Our Ref: MN/7451/App\_240621.  
24<sup>th</sup> June 2021

**Re: Planning application at 69-71 Church Road, Anerley, Crystal Palace, SE19 2TA  
Variation of Conditions 2 & 9 Application – Submitting of comparison drawings.**

In response to the invalidation letter dated 16<sup>th</sup> June for the Variation application for the project at 69-71 Church Road, Anerley, ref: DC/19/03203/RECON, I attach the following drawings with the original approved drawings overlaid in red, as requested, for your consideration.

| Rev  | Date              | Comments    |
|--|-------------------|-------------|
| Drawing No.<br>7451-PD-212   | Revision          |             |

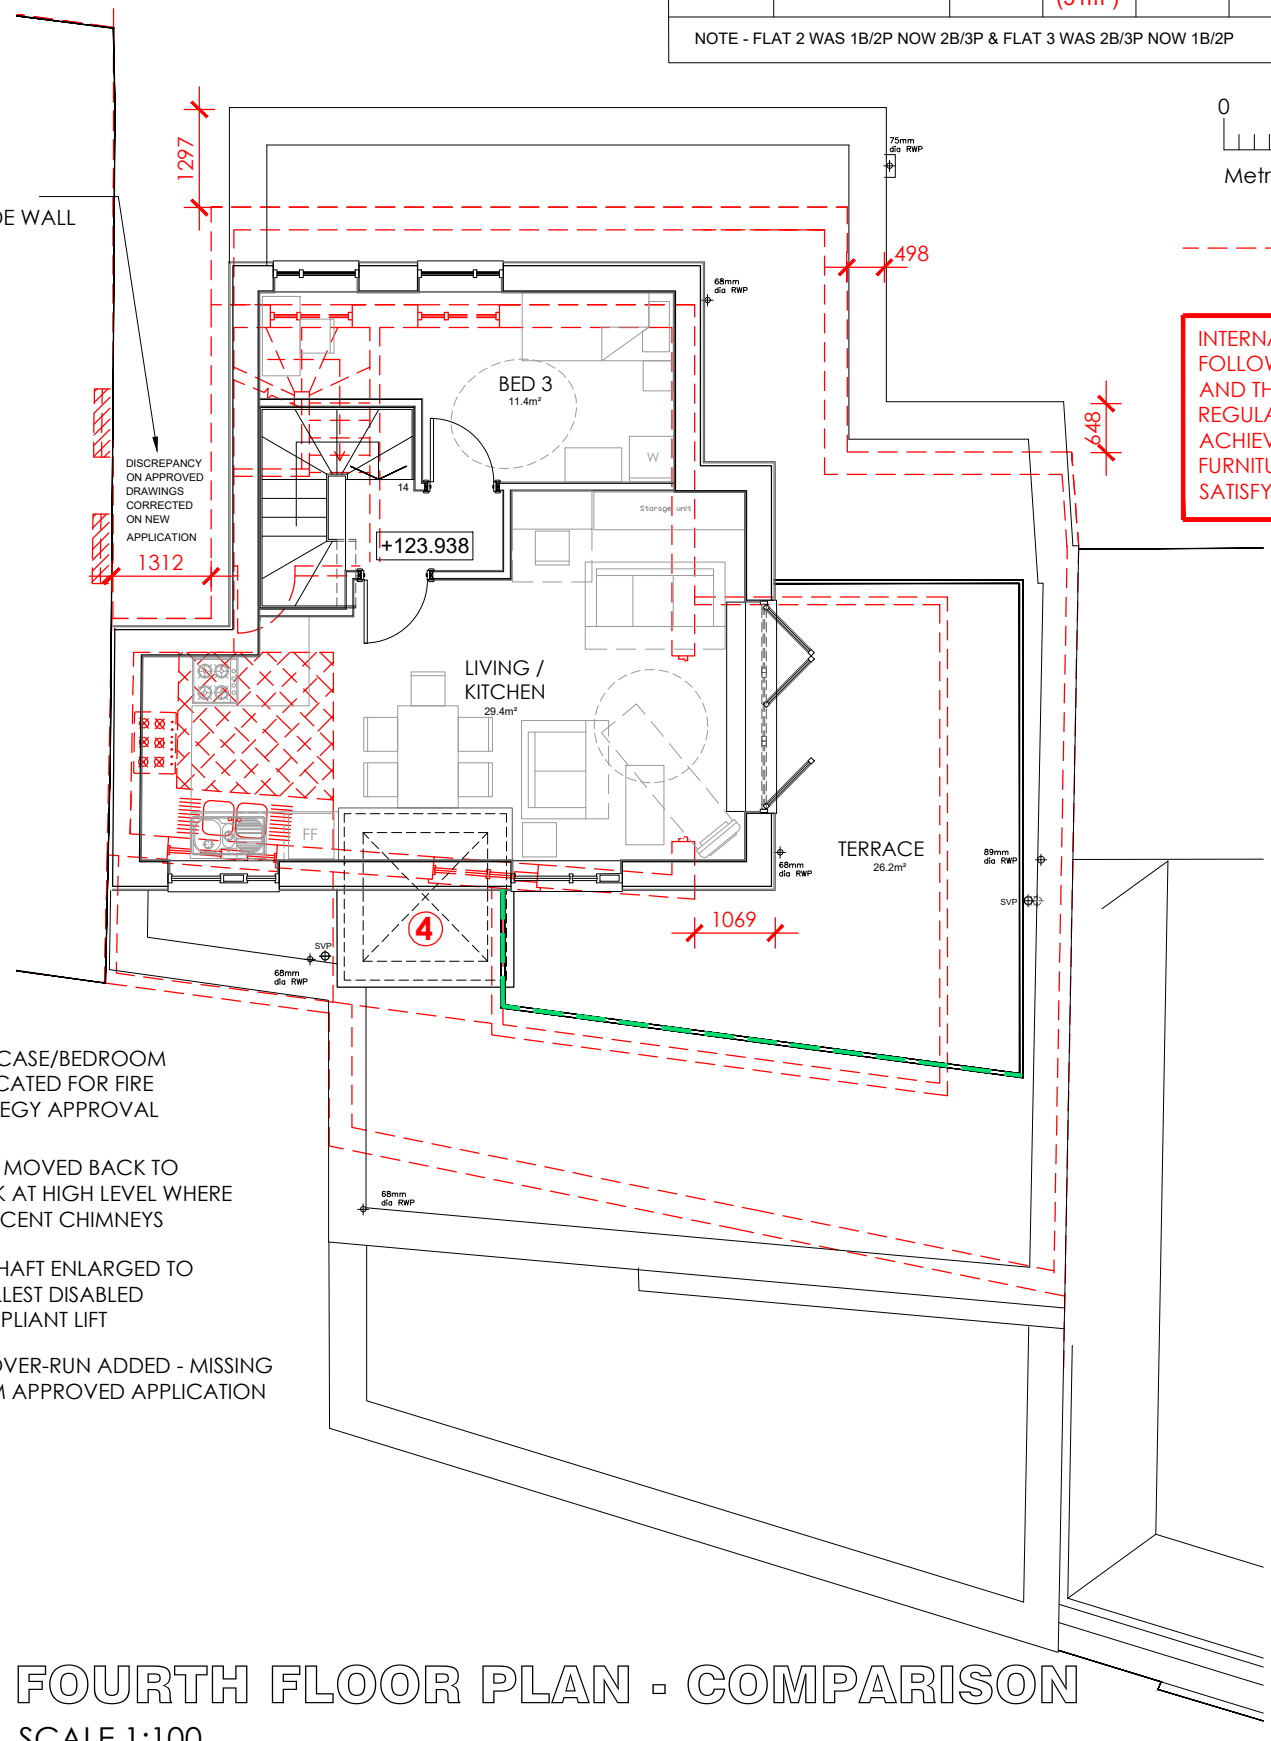
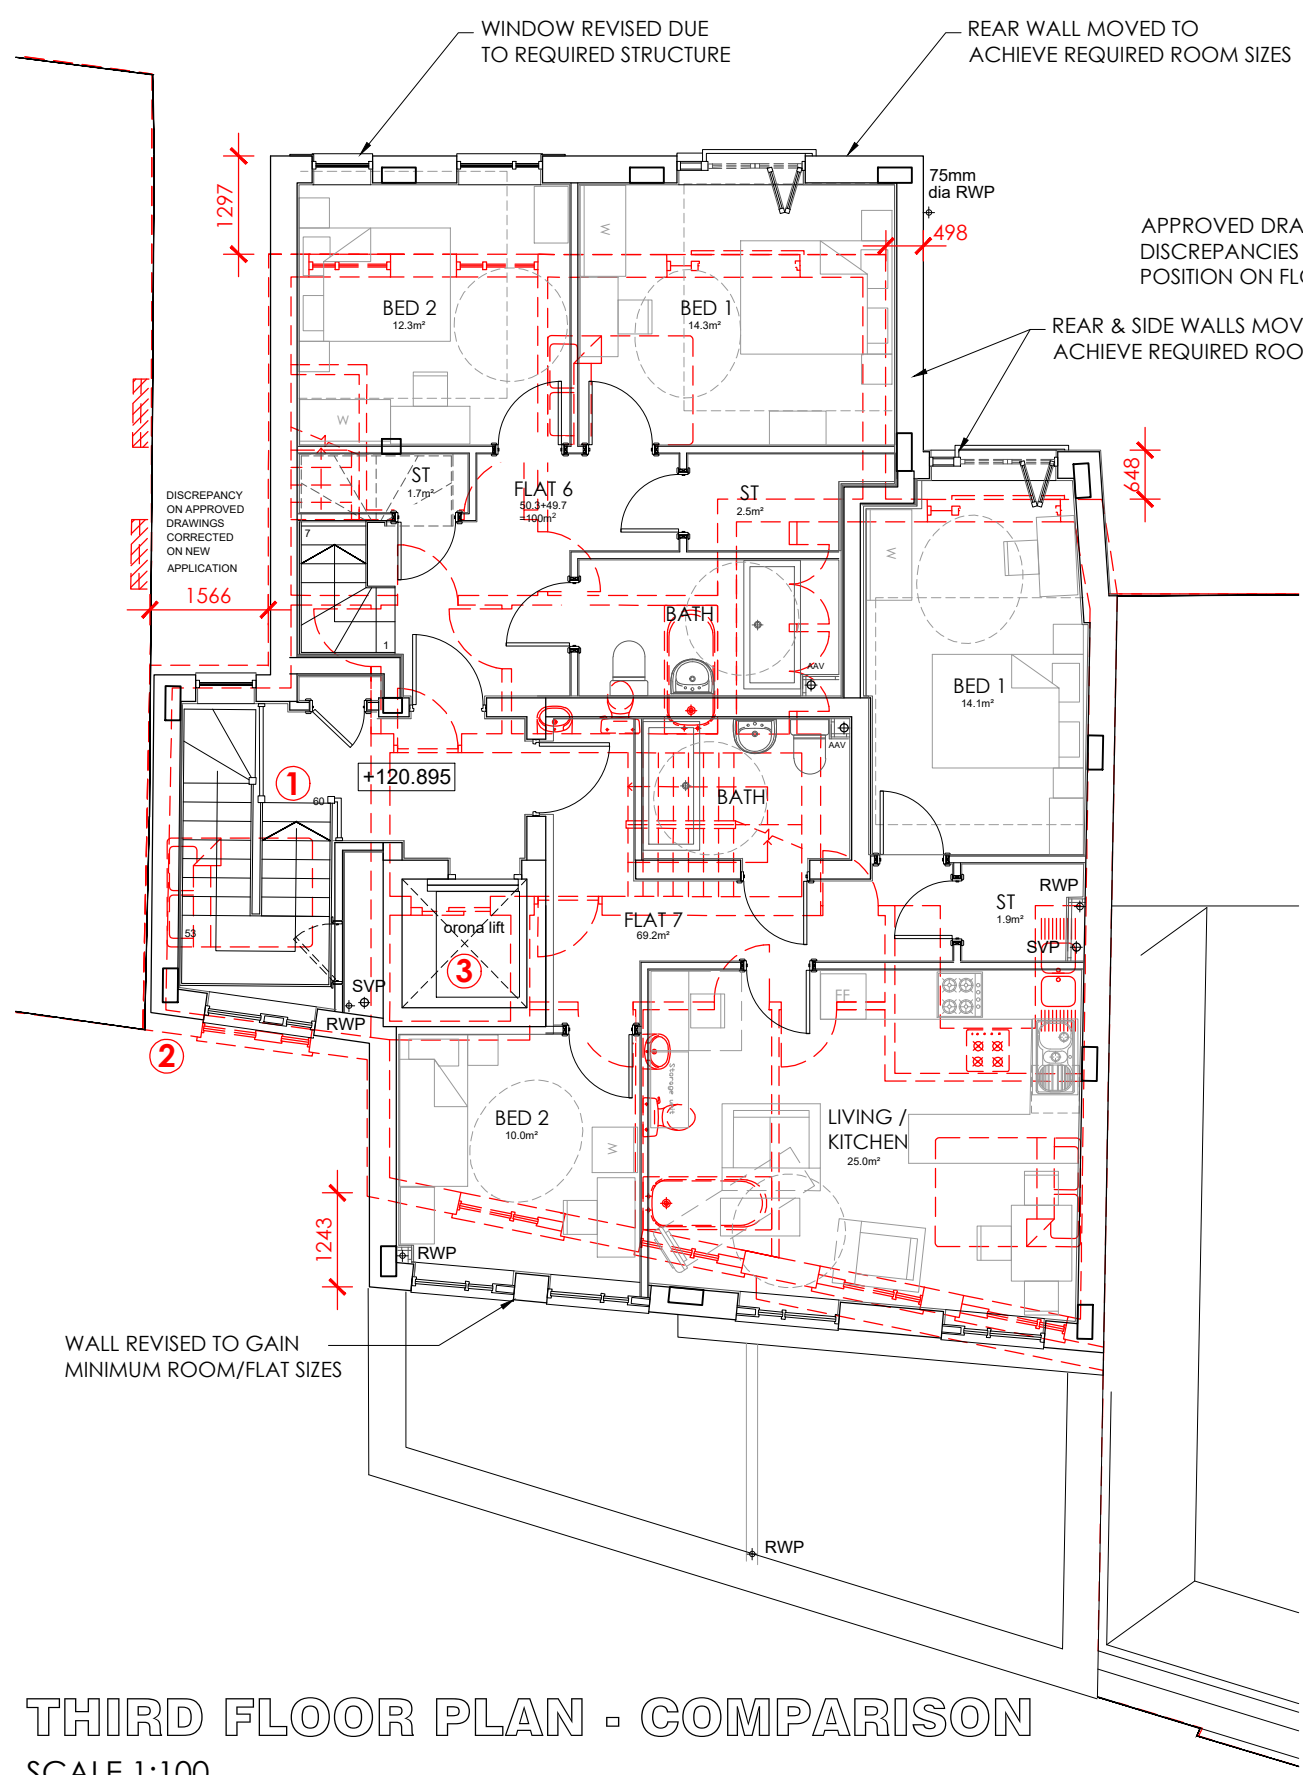
Drawing **7451-PD-212** Third & Fourth Floor Plans

- The lift, as approved, was too small to comply with AD M4(2) requirements. New lift increased to achieve required car size for disabled users.
- Lift over-run added to elevation. Not indicated on approved elevations.

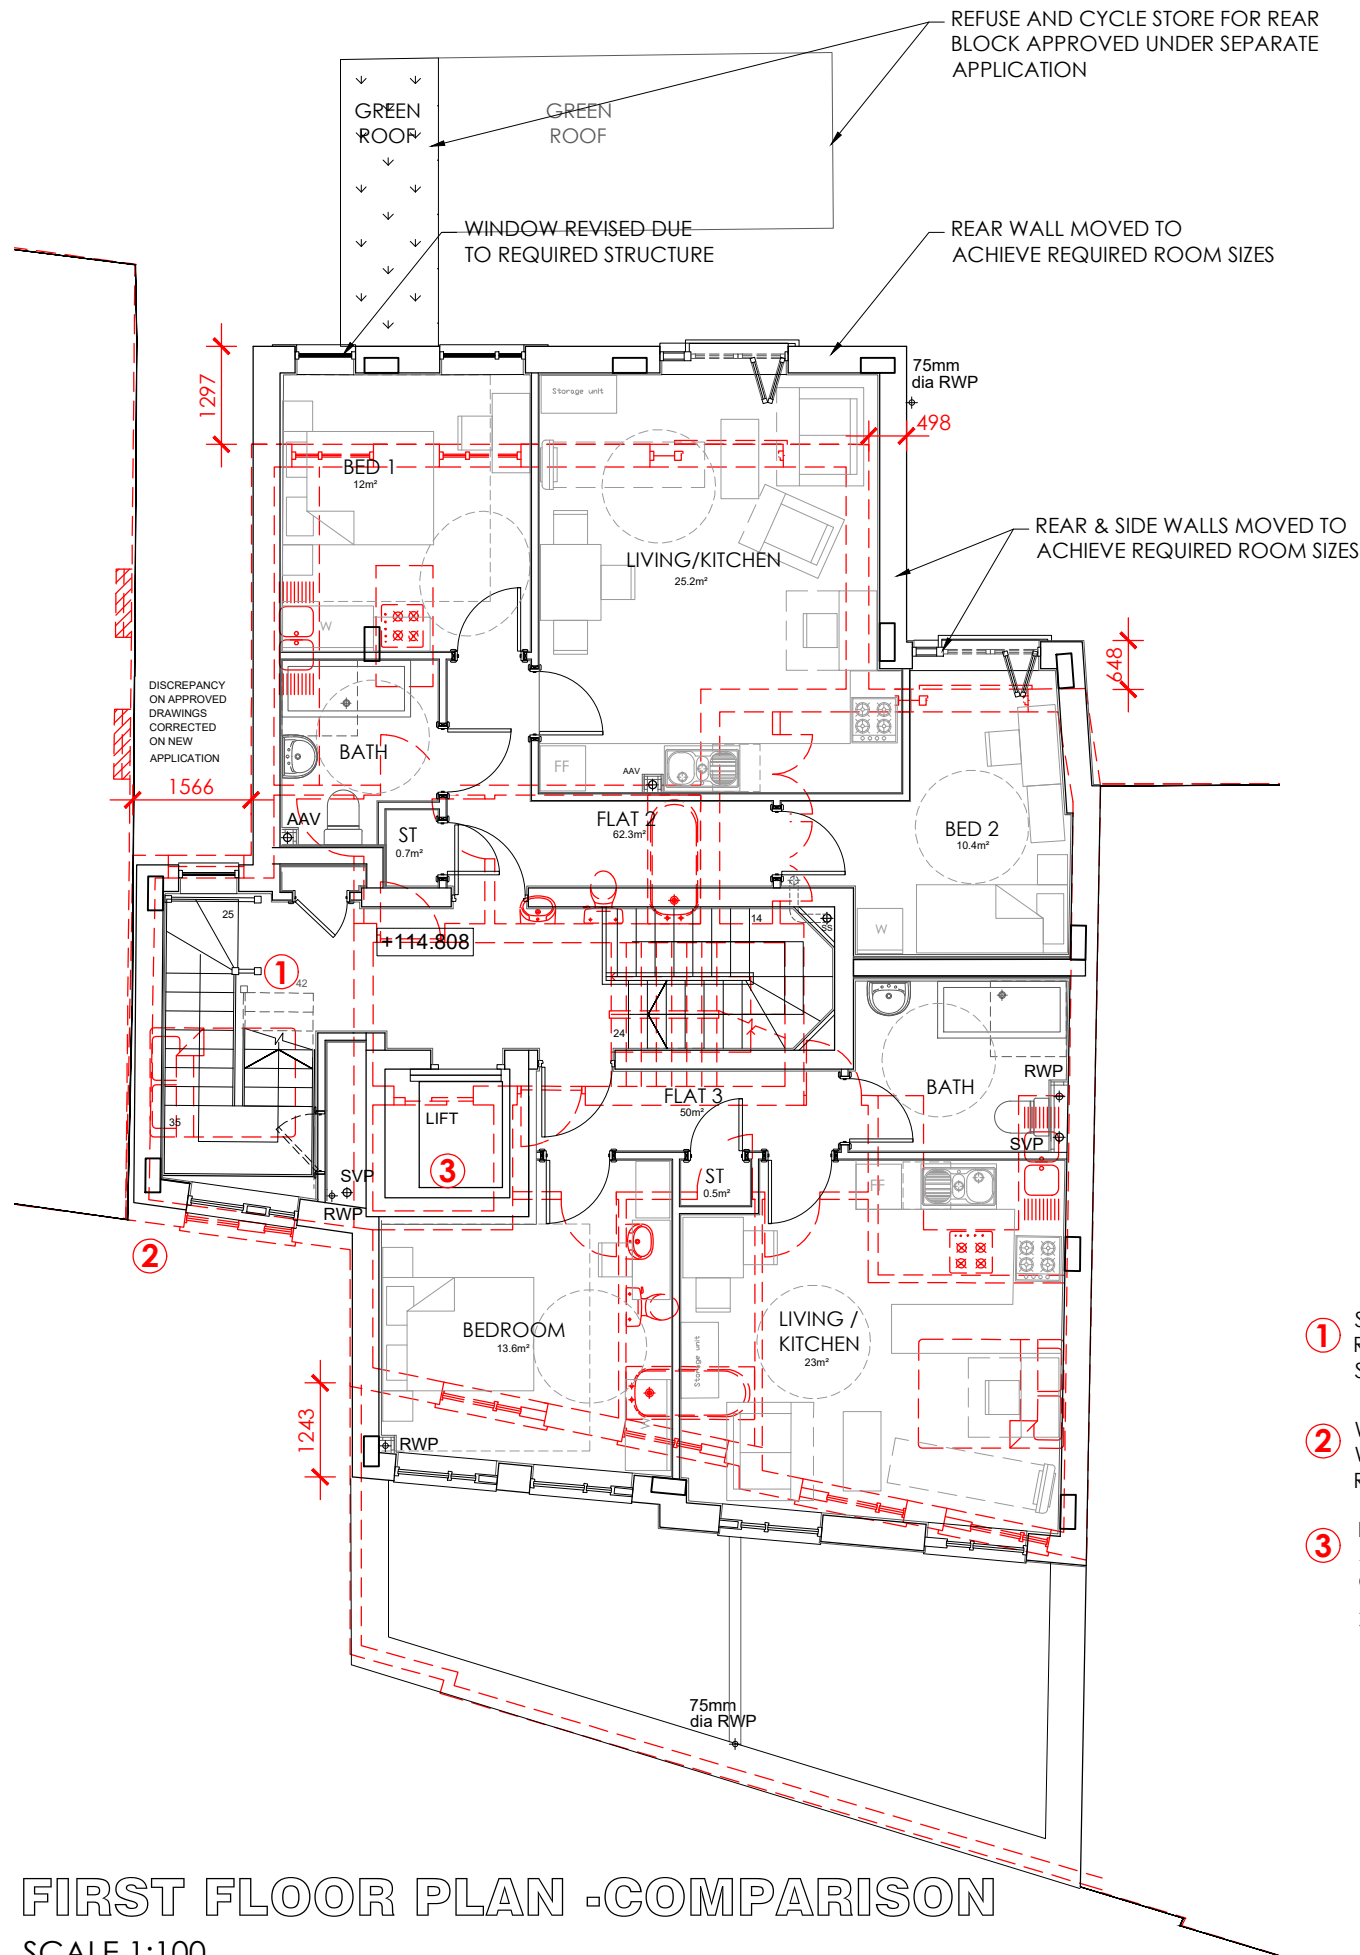
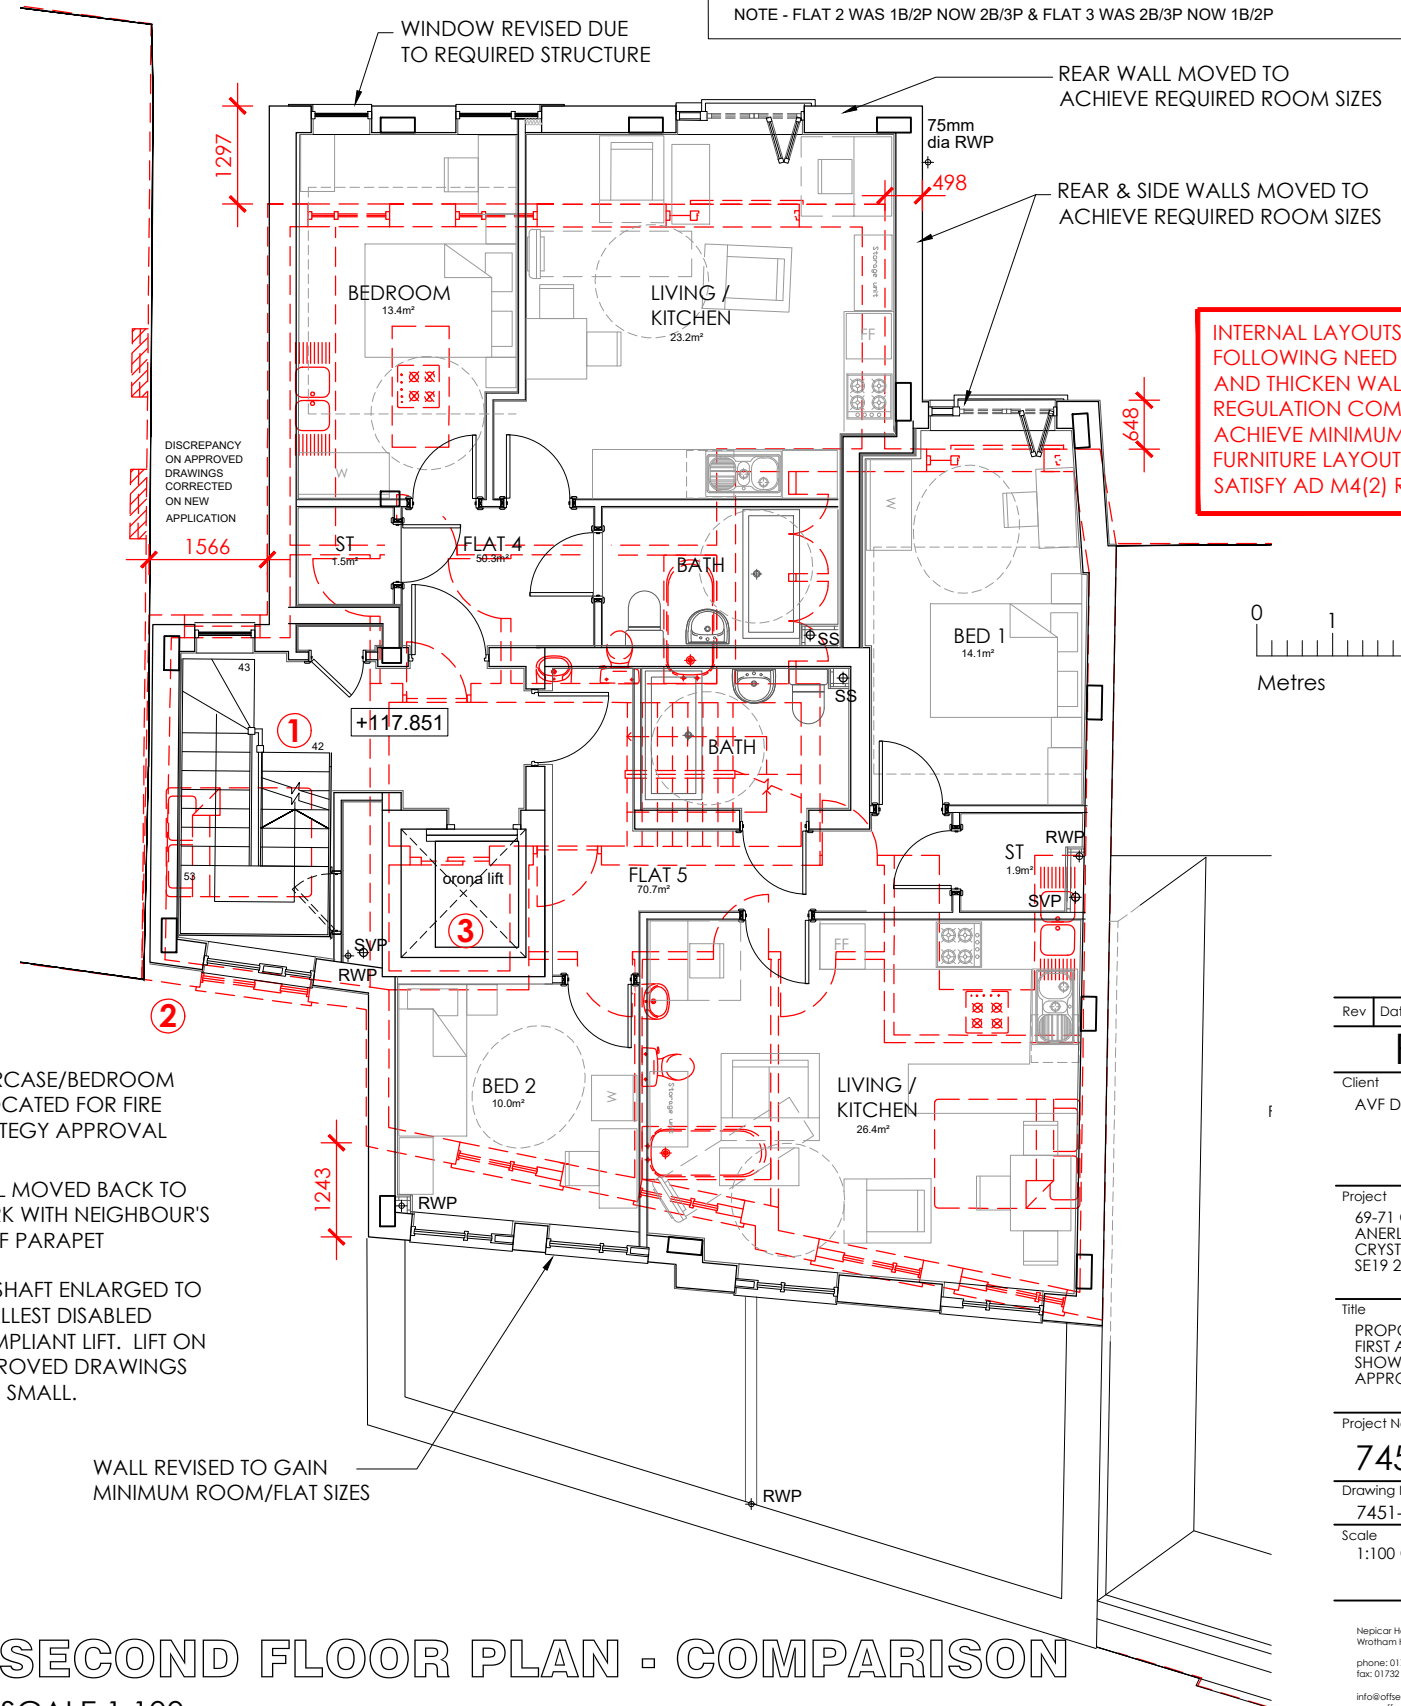
Drawing **7451-PD-211** First & Second Floor Plans

- Floor and wall thicknesses increased where required to achieve required thermal and sound insulation properties to comply with Building Regulations.
- Angle of front wall of residential units revised to gain required space to comply with flat / room sizes / furniture layouts.
